TfNSW Reference: SYD20/01320/11

Departments Reference: SSD-11070211-MOD-1

AMMENDED APPLICATION - SECTION 4.55 MODIFICATION TO MULGOA RISE PUBLIC SCHOOL - 1-23 FORESTWOOD DRIVE, GLENMORE PARK

Figure 5 - Pedestrian Access

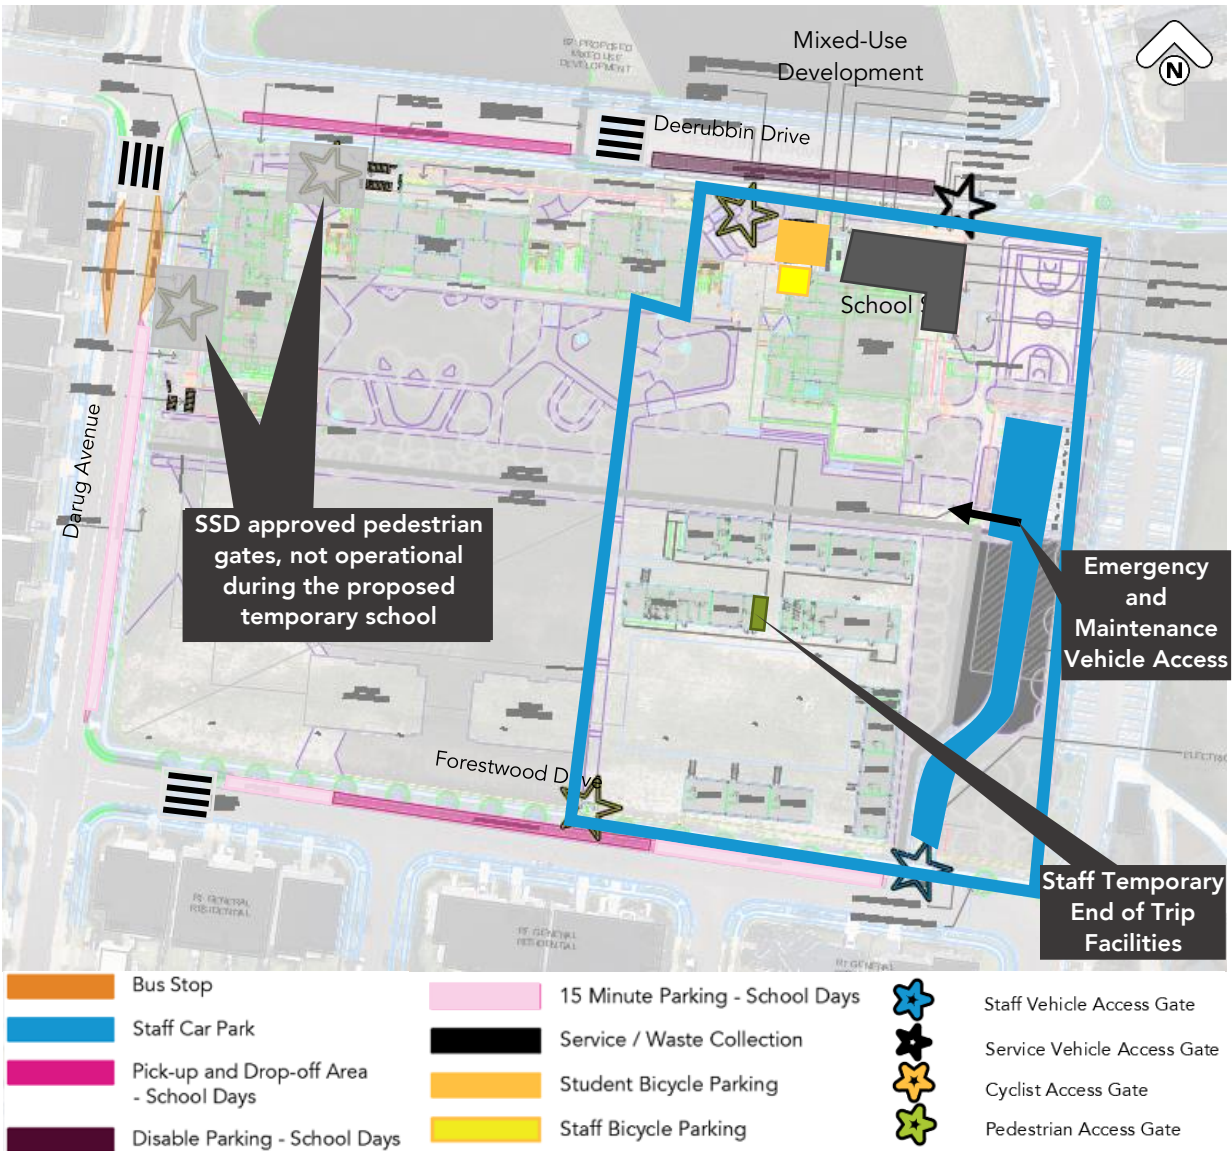
1. It is advised that the proposed zebra crossing and other traffic facilities will require community consultation with affected residents and concurrence from the Local Traffic Committee prior to implementation.
2. TfNSW is responsible for speed management along all public roads within the state of New South Wales. That is, TfNSW is the only authorised organisation that can approve speed zoning changes and authorise installation of speed zoning traffic control devices on the road network within New South Wales.
